CITY OF ALBUQUERQUE

**Planning Department
Transportation Development Services Section**

Re: Certification Submittal for Final Building Certificate of Occupancy for
Office Warehouse, [L-20 / D064]
601 General Hodges SE
Architect's Stamp Dated 01/07/09

**RE: 'OFFICE WAREHOUSE' LOCATED AT 601 GENERAL
HODGES S. E., ALBUQUERQUE, N. M.**

ALL LANDSCAPING WILL BE IN CONFORMANCE W/CITY OF ALBUQ. ZONING CODE, STREET TREE OR'D POLLEN, WASTE WATER & WATER CONSERVATION LANDSCAPE ORDINANCES

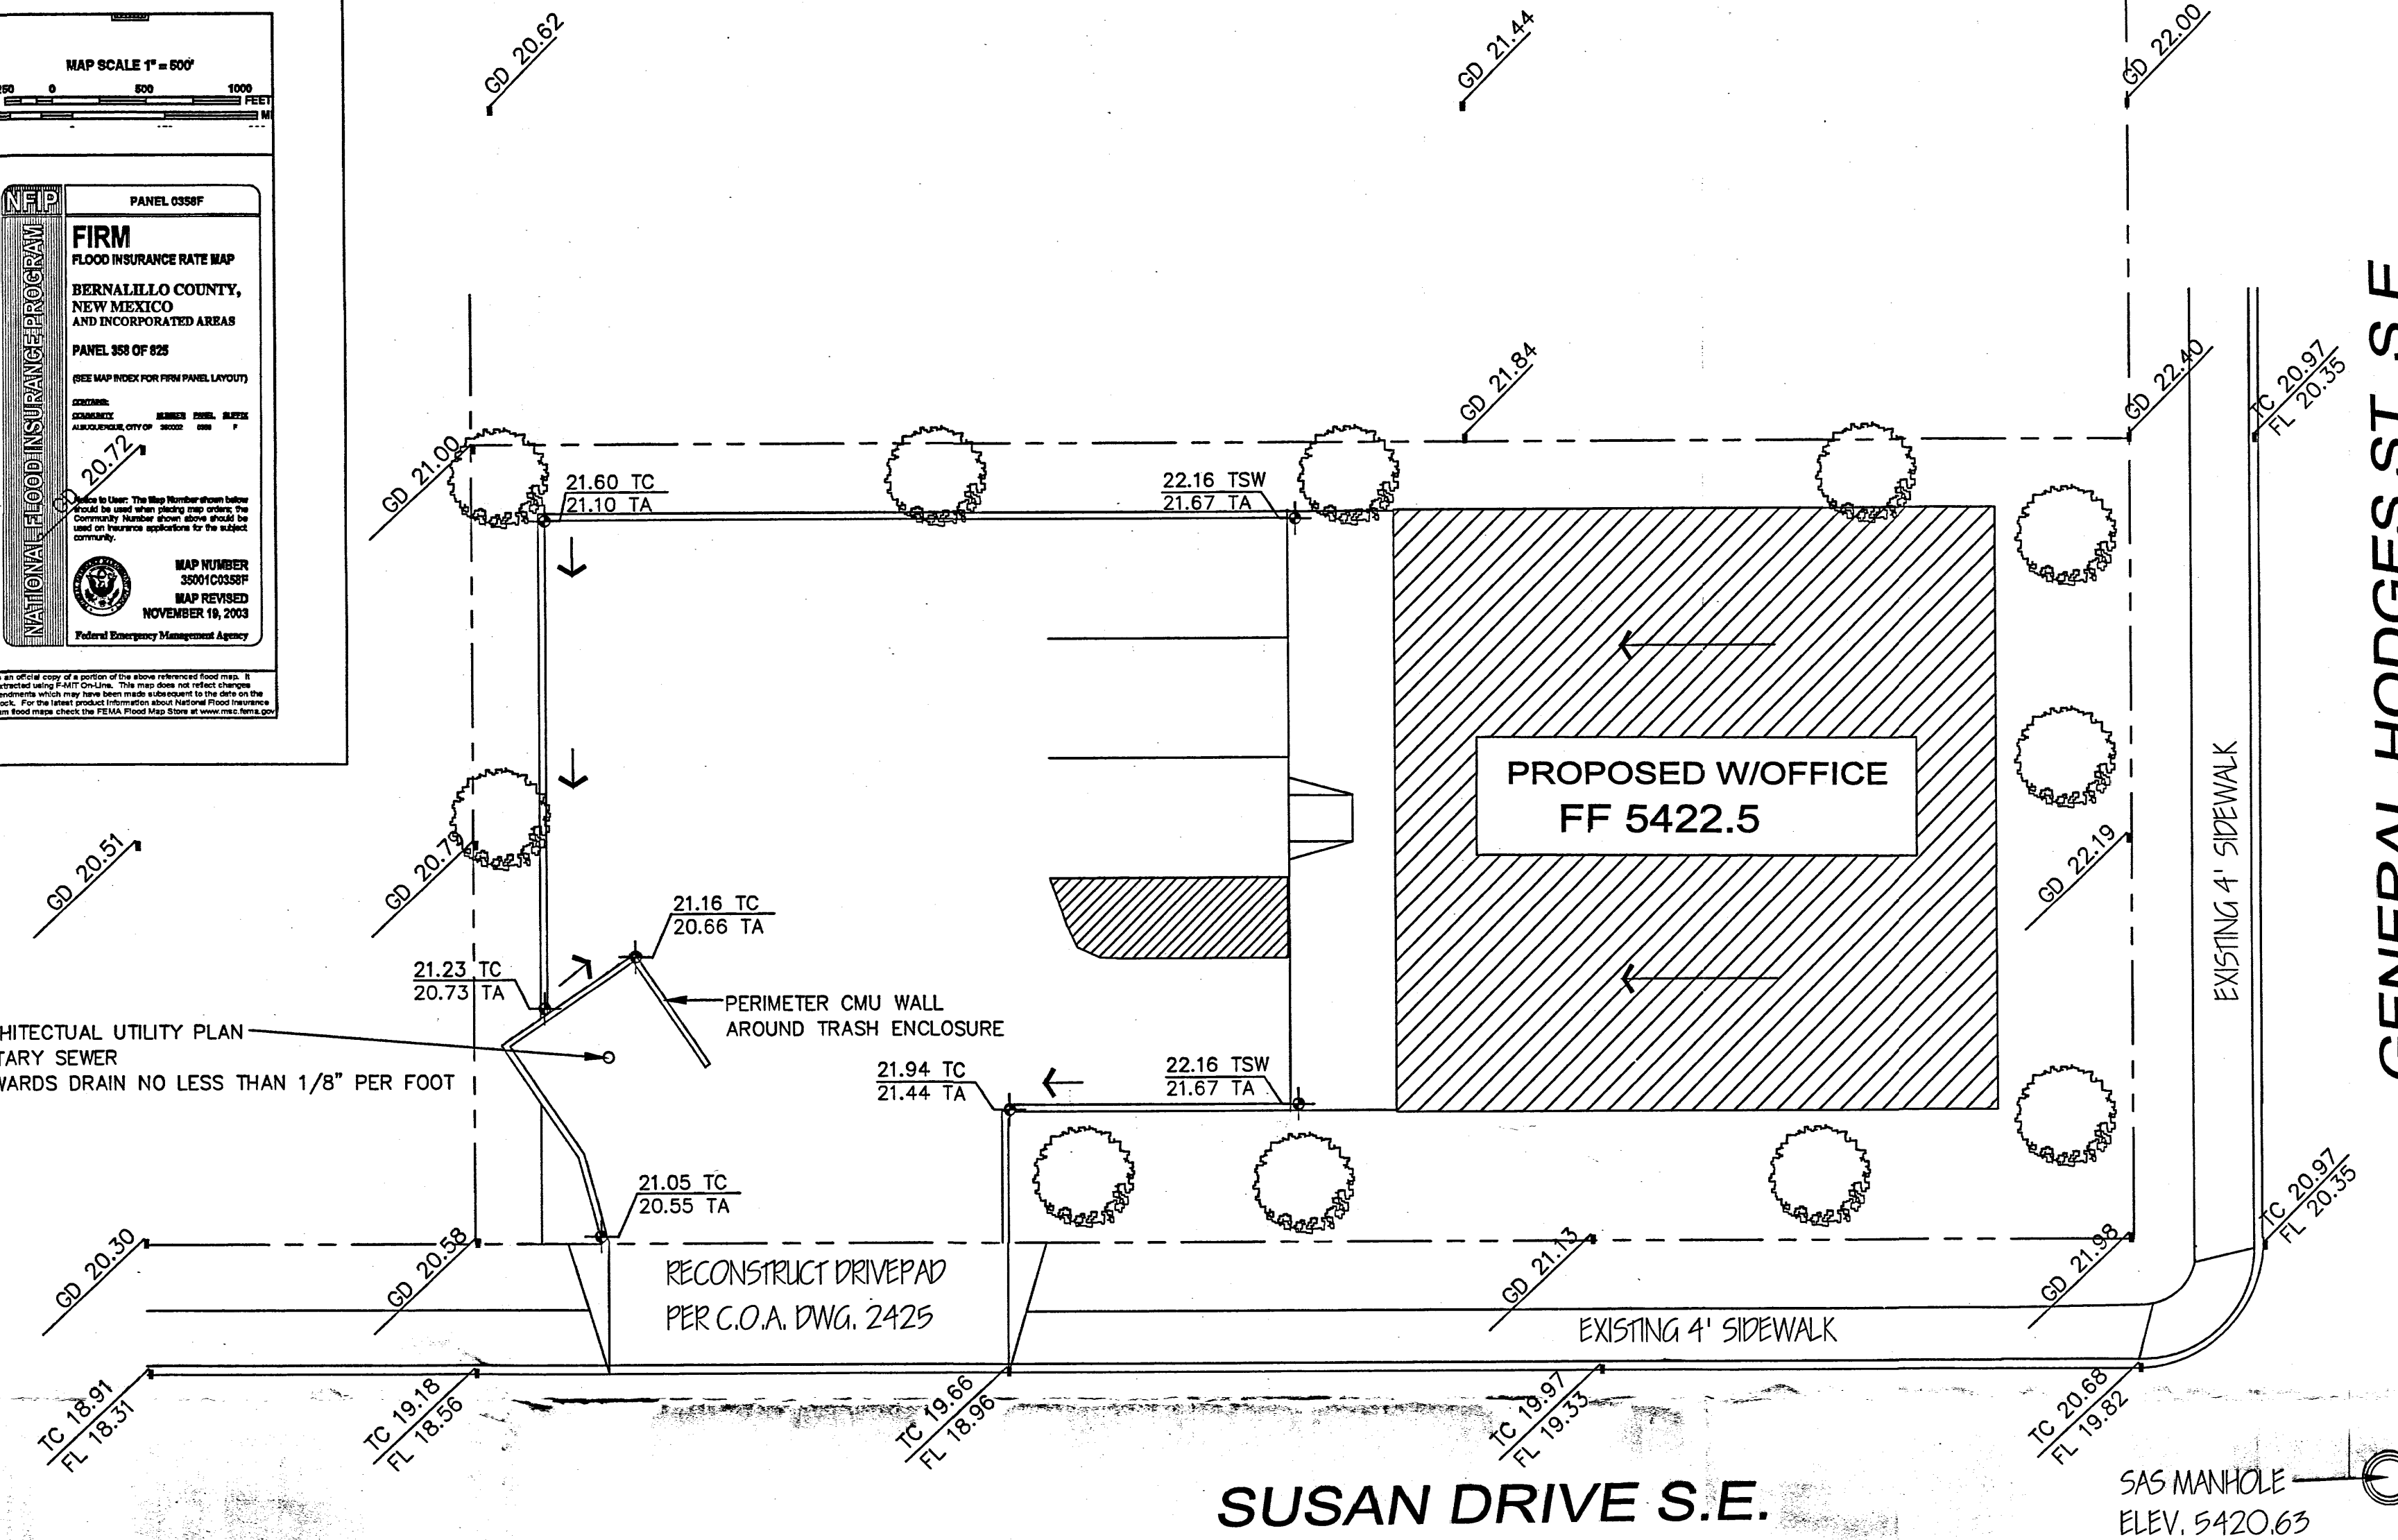
- ✓1. Call out the width of the existing sidewalk.
- ✓2. Show the heavy vehicle path. How will loading occur?
- ✓3. Dimension the van access aisle.
- ✓4. Do the ramps at Susan and General Hodges meet current ADA criteria; if not they will need to be replaced.
- ✓5. Include a vicinity map on the plans.
- 6. Call out the distance between the ramp and the edge of sidewalk ^{to the east} for the handicapped detail. This distance should be a minimum of 3', or consider a different type of ramp.

→ CoA Std 2425 does not have wheel chair ramps. Please amend your plan accordingly.

GRADING & DRAINAGE PLAN

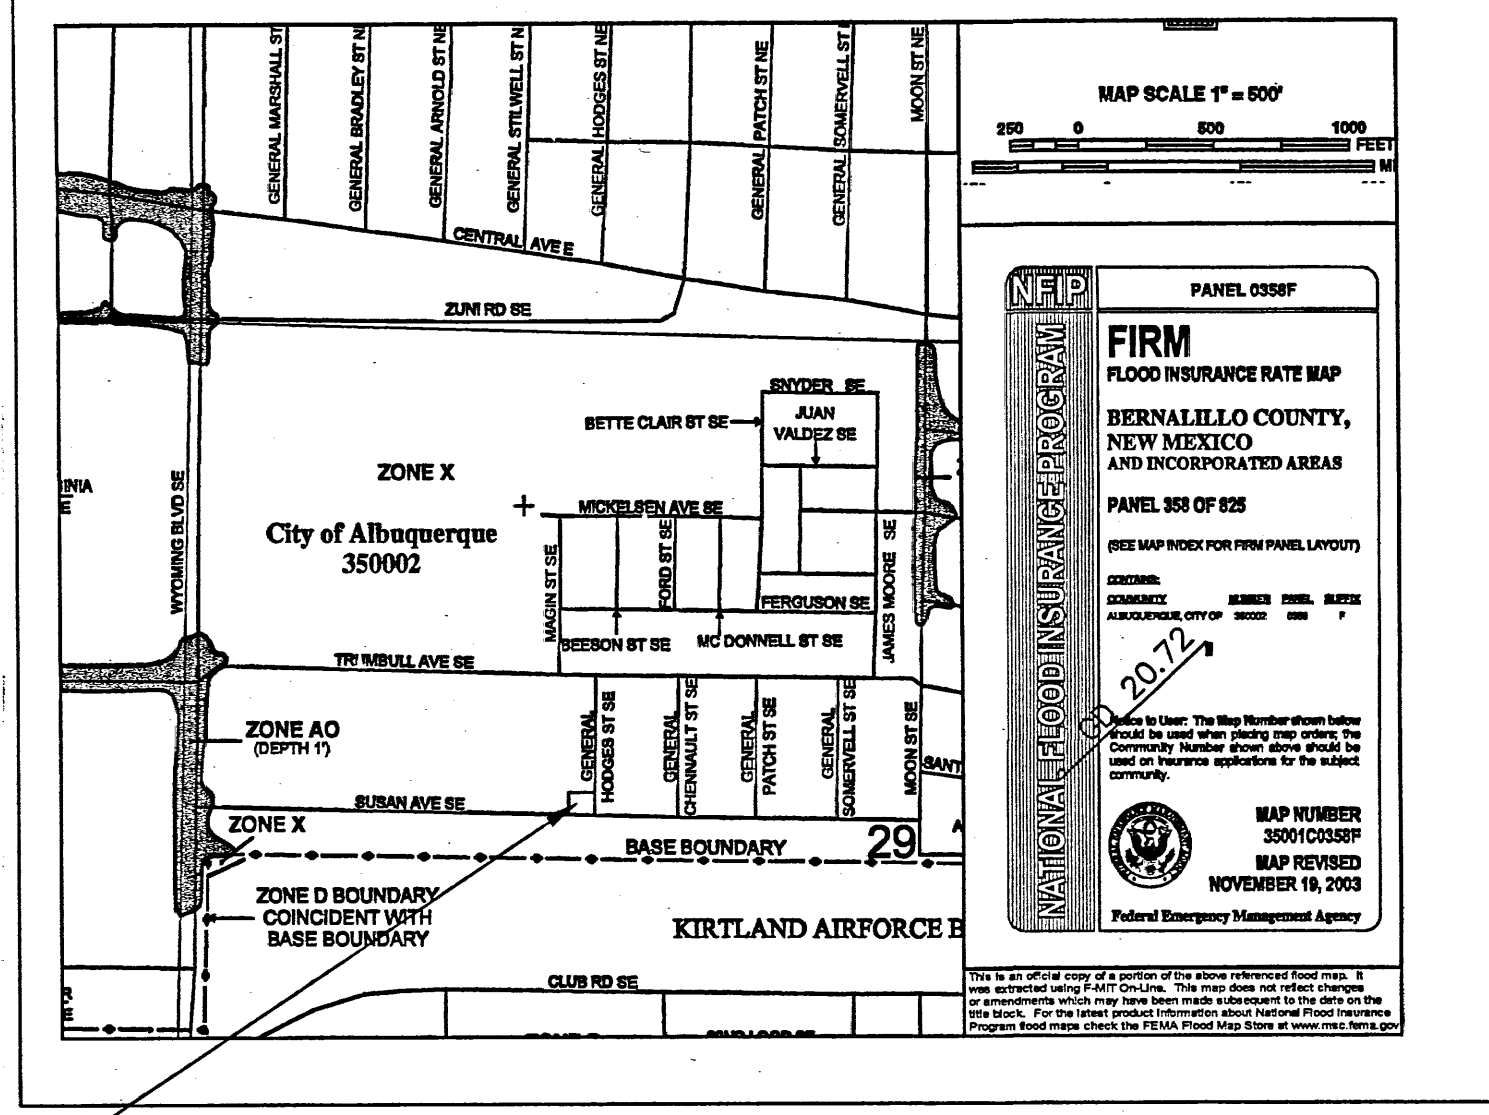
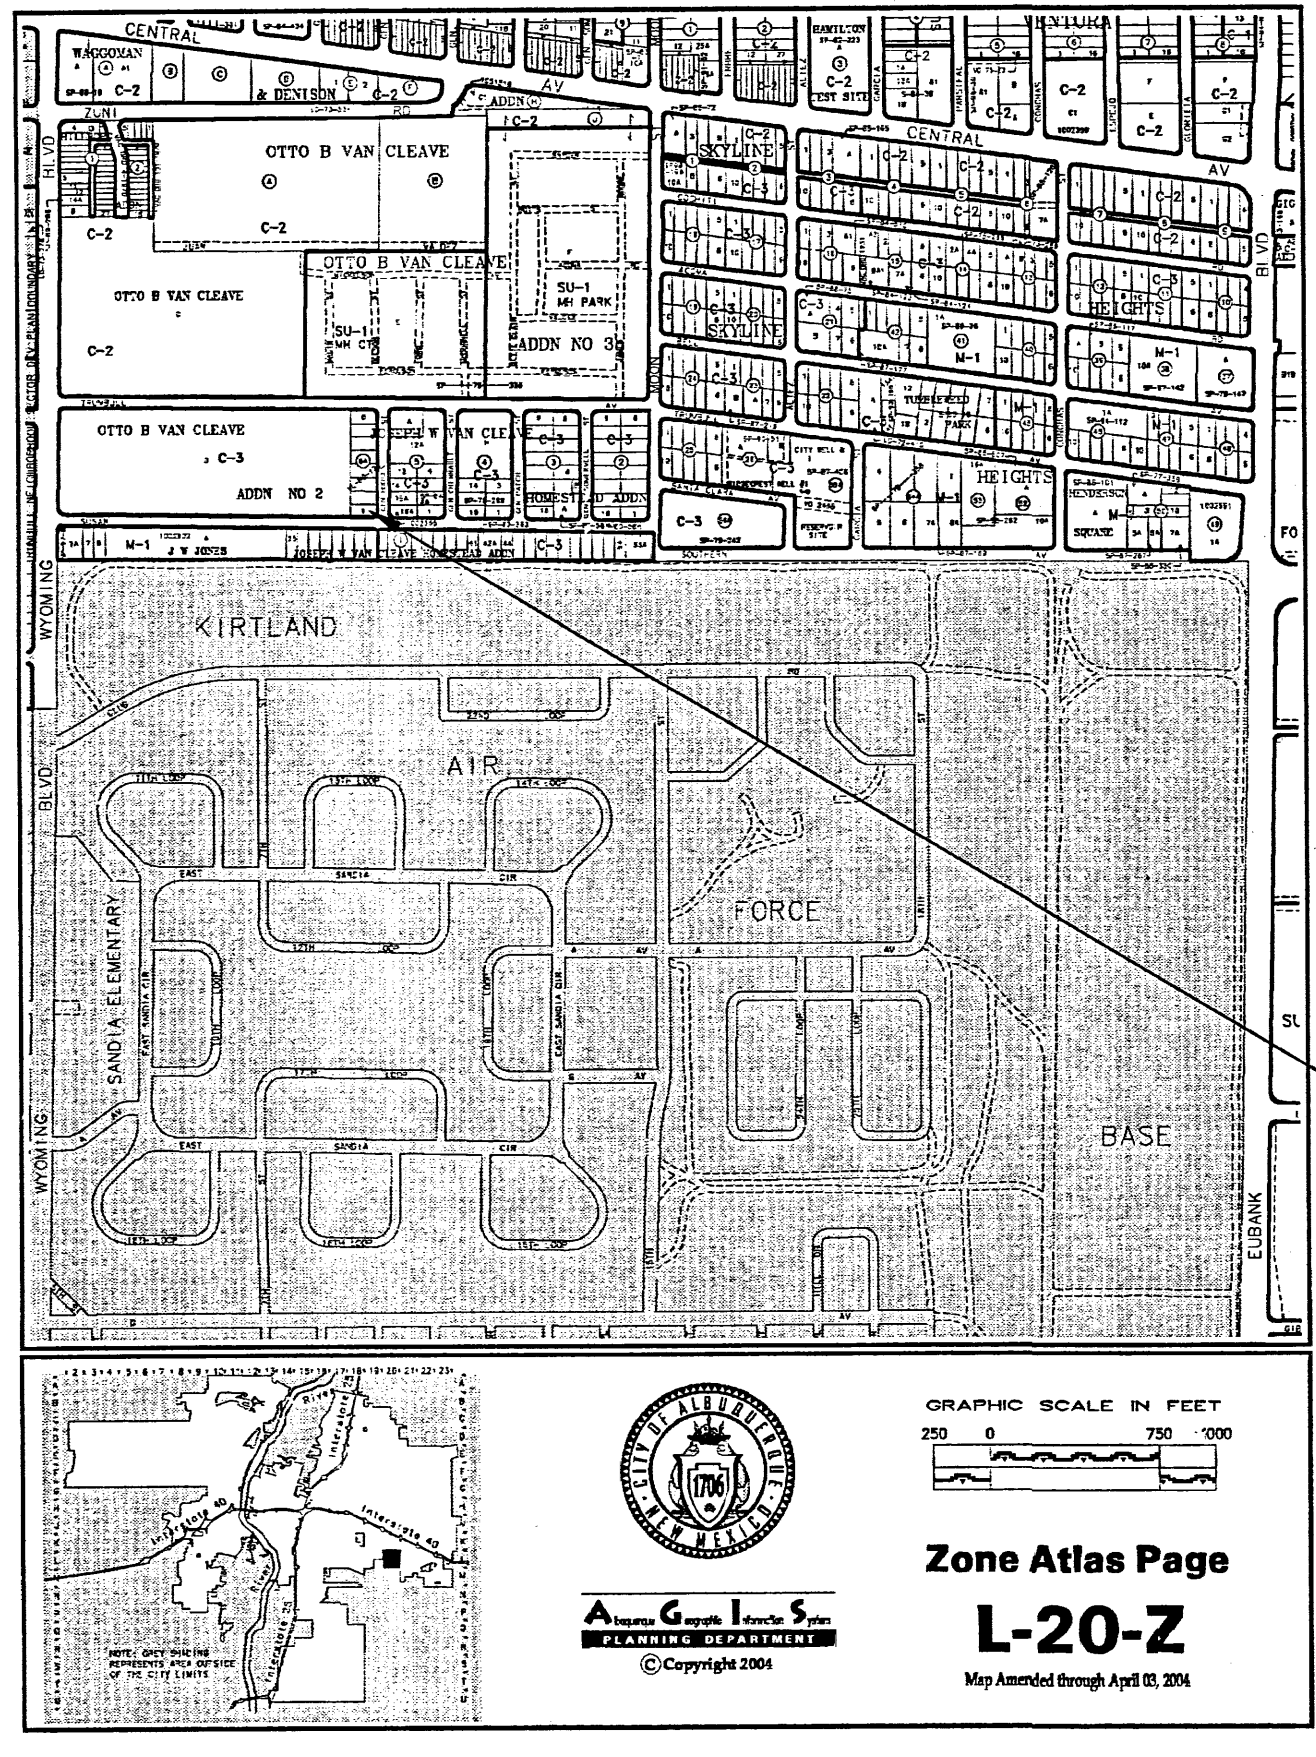
- Add a drain to the dumpster enclosure to drain the runoff from the dumpster enclosure to the sanitary sewer.

There was a recent change to the DPM Chapter 22 Section 9 so that “.. new development and projects that require drainage plans do not increase post-development pollutant loads from the project site.”
Projects include “Dumpster, Compactor and Waste Collection and Storage Pads on all commercial and industrial sites”

- Runoff cannot drain through the dumpster enclosure. Also, add a drain to the dumpster enclosure that connects to the sanitary sewer.
- Provide spot elevations or contours for the lots to the north and west of this site.
